from
**Southern
Water**

Our ref
PLAN-040799

Proposal: Development of 2 No. 2-bed & 2 No. 3-bed detached dwellings & associated works (resubmission following CM/53/20/PL). This site is in CIL Zone 3 & is CIL Liable as new dwellings.

Site: CM/17/21/PL: - Land at Wren Cottage, Horsemere Green Lane, Climping, BN17 5QZ.

SITE PLAN
SCALE 1:500 @ a3

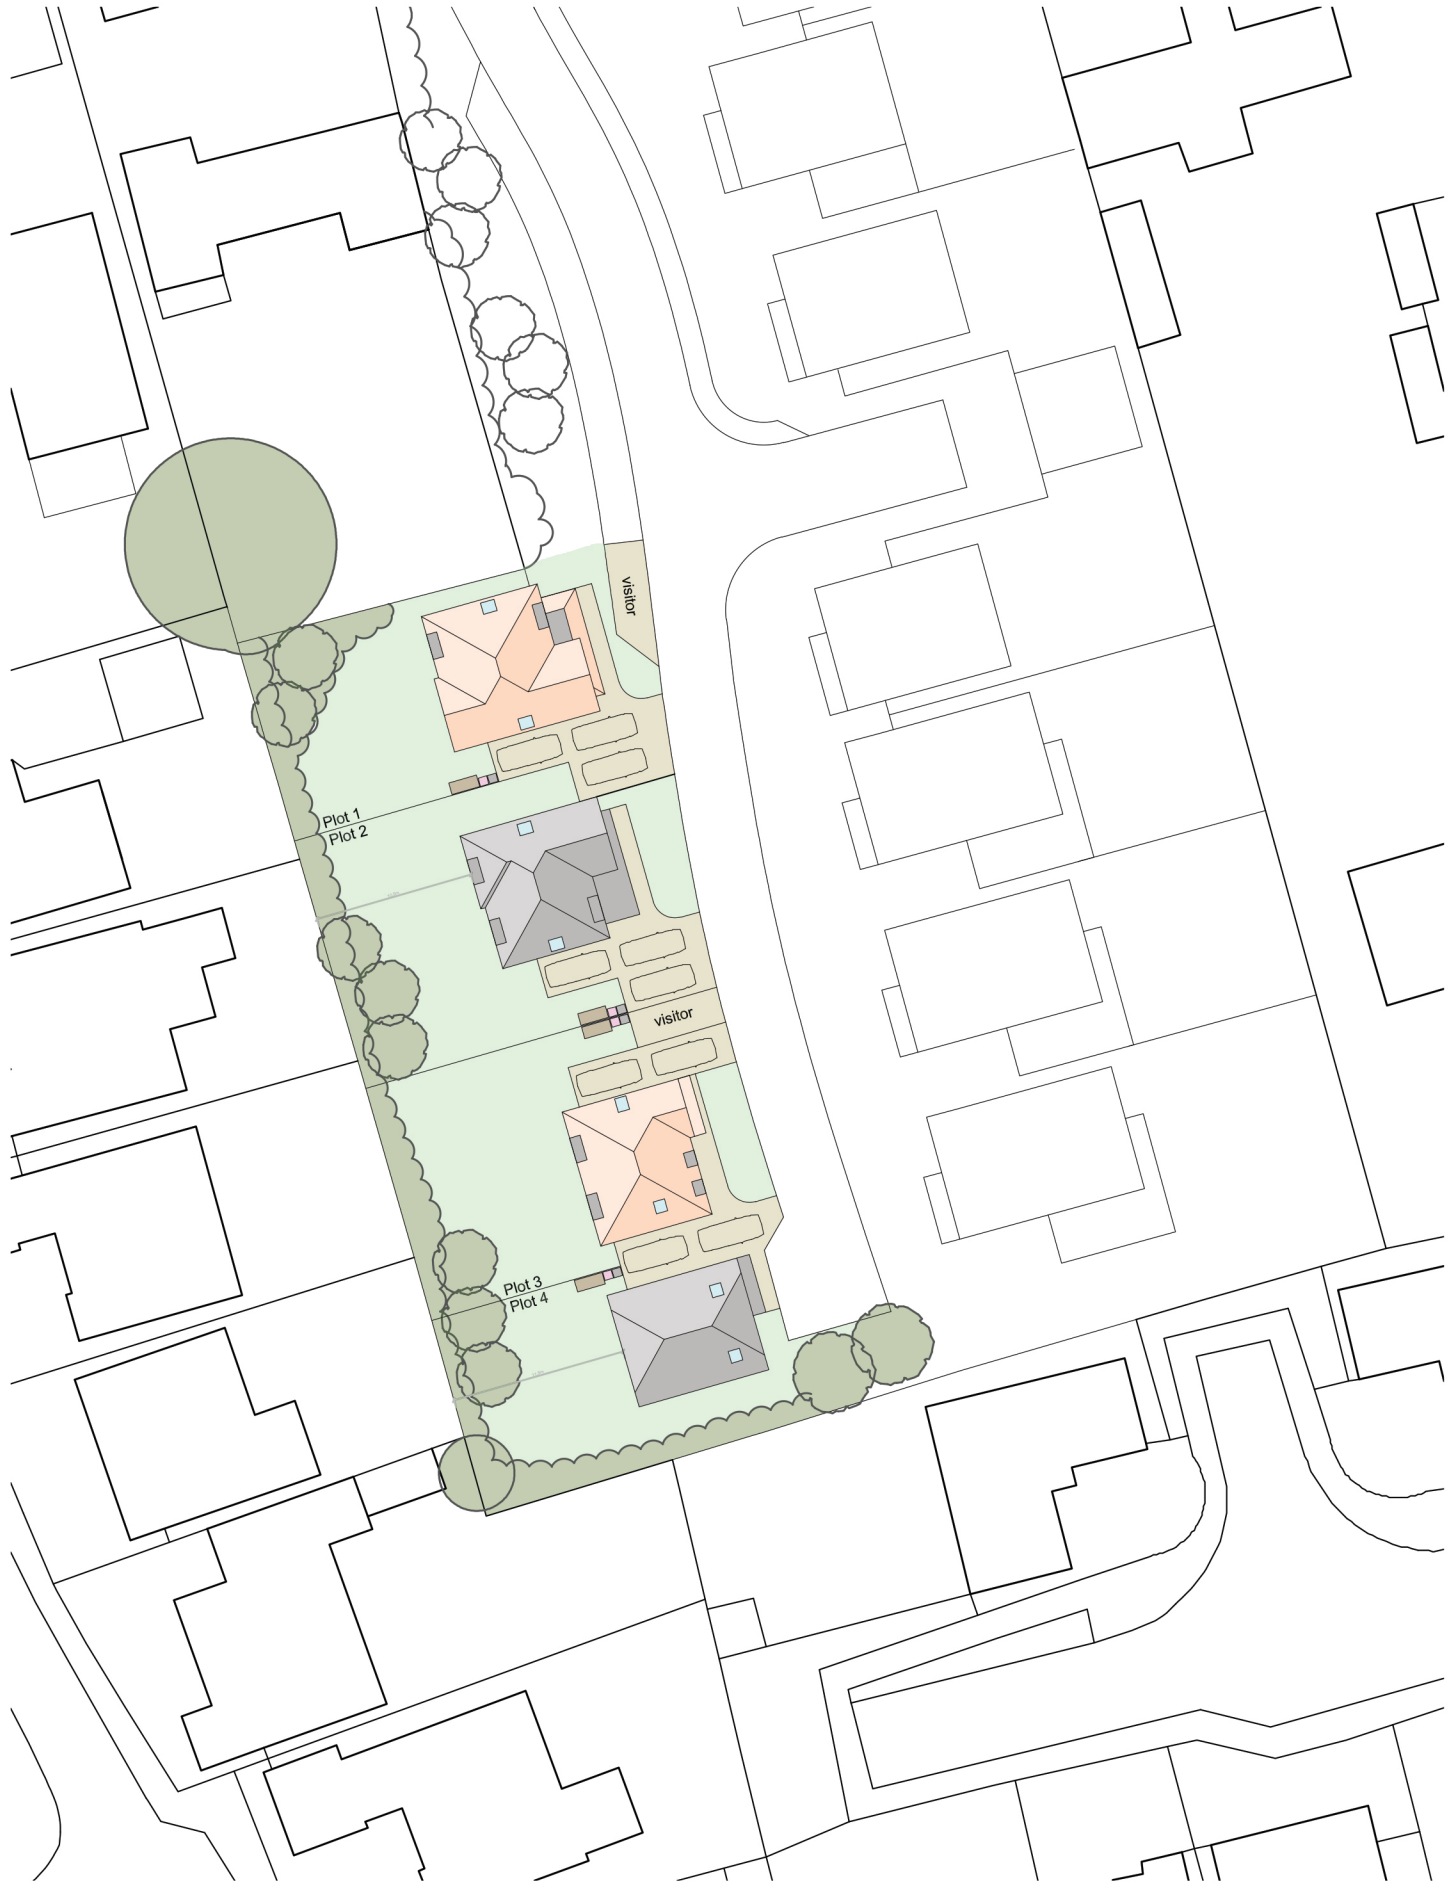
Please see the attached extract from Southern Water records showing the approximate position of our existing foul sewer within the access of the development site. The exact position of the public asset must be determined on site by the applicant in consultation with Southern Water.

- The 150 mm diameter gravity foul sewer requires a clearance of 3 metres on either side of the gravity sewer to protect it from construction works and to allow for future maintenance access.
- No development or tree planting should be carried out within 3 metres of the external edge of the public gravity sewer without consent from Southern Water.
- No soakaways, swales, ponds, watercourses or any other surface water retaining or conveying features should be located within 5 metres of public or adoptable sewer.
- All existing infrastructure should be protected during the course of construction works.
